Planning Consultation Memo

Date	Planning Officer	Environmental Health Officer
18/03/2020	David Elmore	Karl Riahi
Planning Application Number	Worksheet Number	
6/2020/0311/MAJ	WK/116310

Address: Nyn Park, Well Road, Northaw, Potters Bar, EN6 4BS

Application Details: Engineering works comprising ground works and shaping of land to create a golf course (used only in conjunction with the Nyn Park Estate dwellinghouse) and erection of an associated single storey maintenance building

Drawing Title:  
**Location Plan**

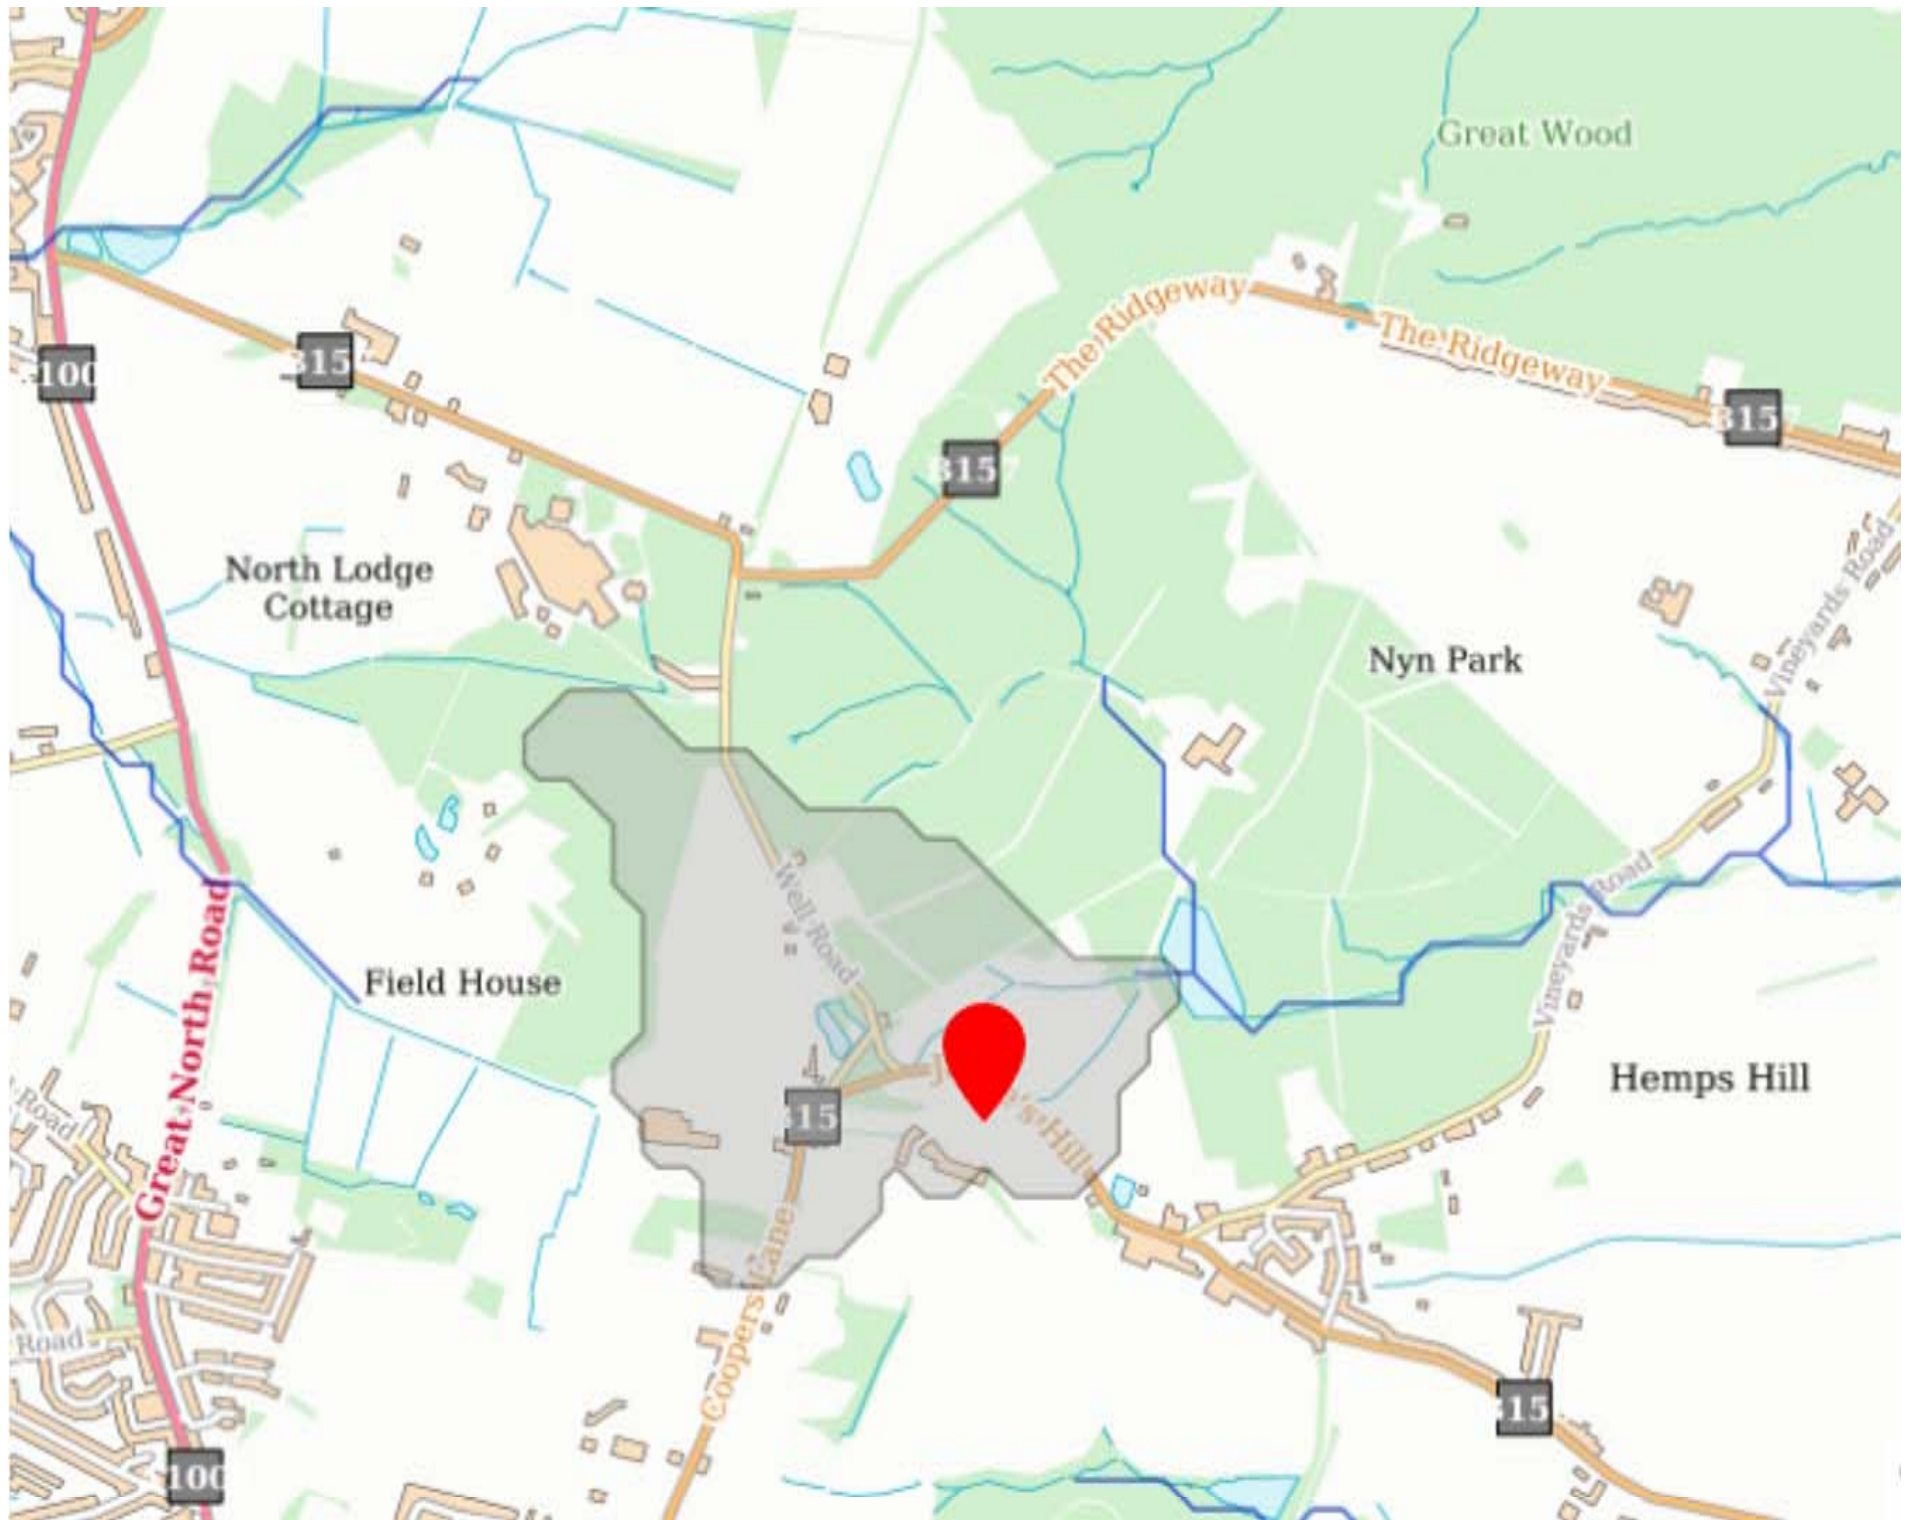
An area of potential contamination is showing within the blue boundary area on the location plan, however, it is over 300m from the area set aside as requiring engineering works for the proposed golf course.

Proposed Floor Plan

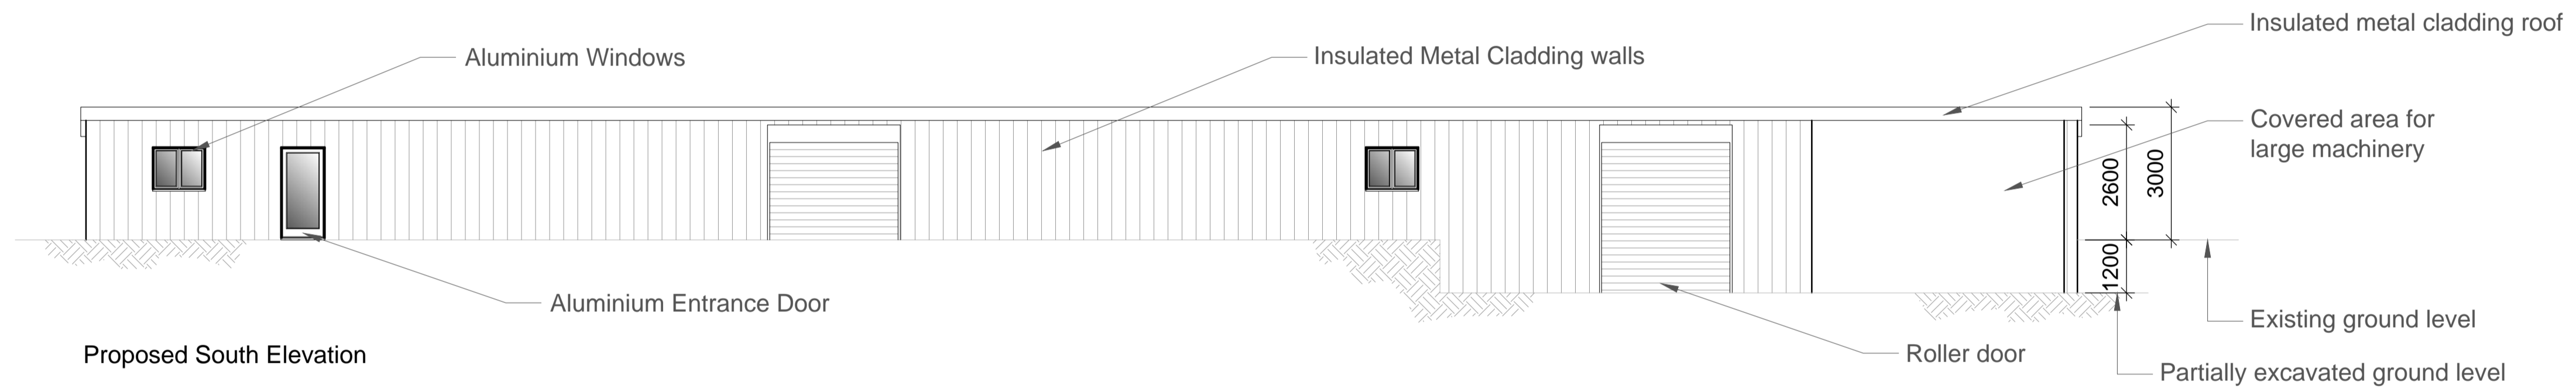
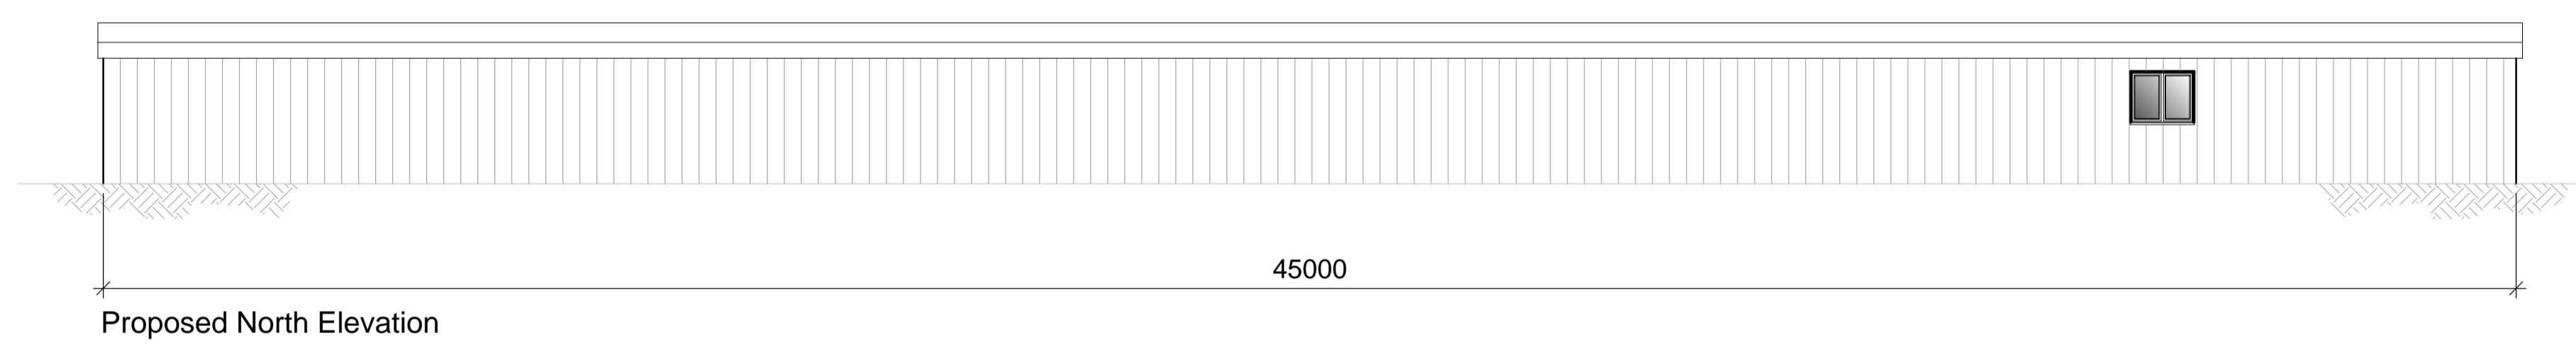
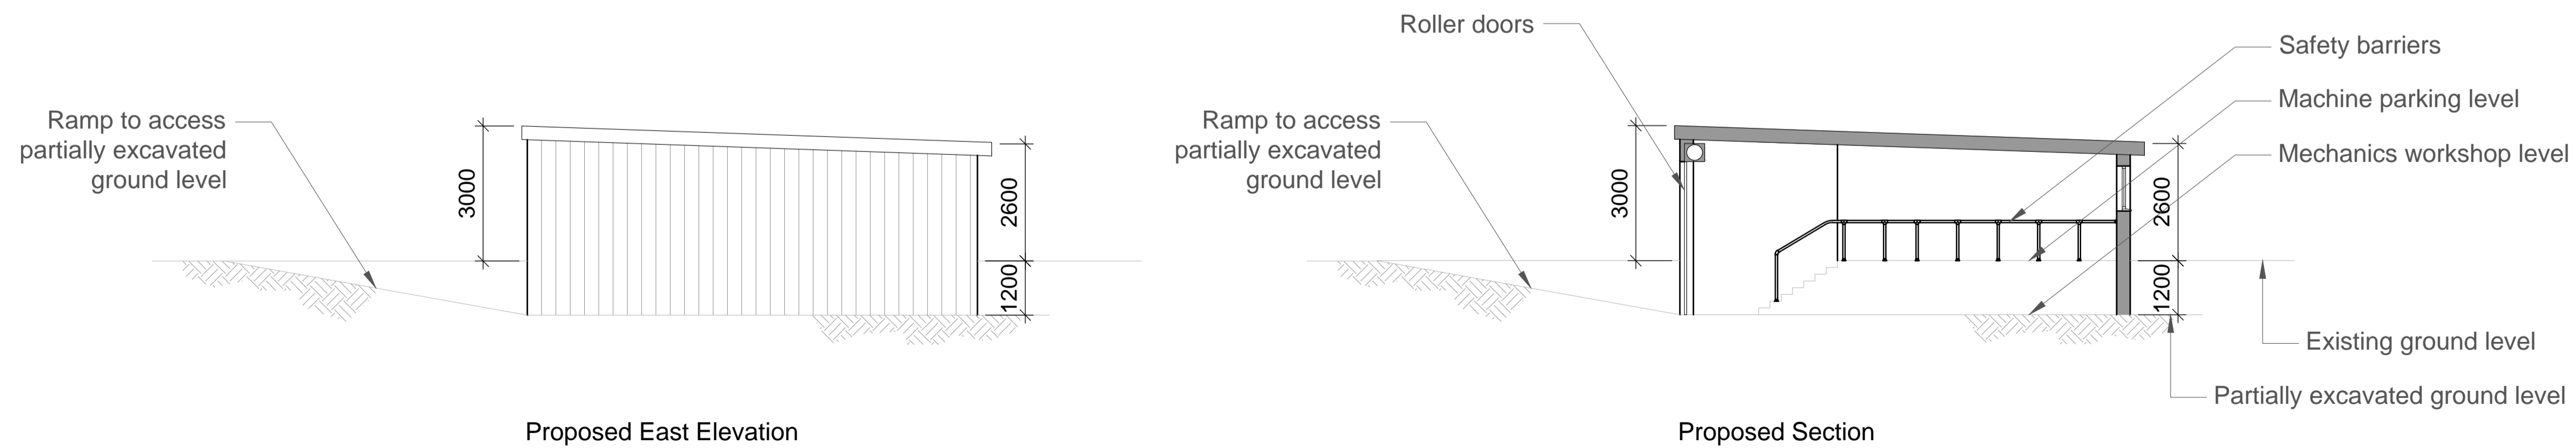
The location of the proposed hut appears to be approximately 150m from the nearest residential property, this distance should help attenuate noise associated with plant/equipment and maintenance.

Depending on what plant/equipment such as air conditioning is to be installed, it is recommended that the standard plant and equipment condition is placed on the application.

Noise from plant and equipment associated with the development shall be 10dB (LAeq) below the background noise level (LA90) at the nearest residential properties (5dB below the background noise level if evidence is provided which shows that no tonality or other character is present).
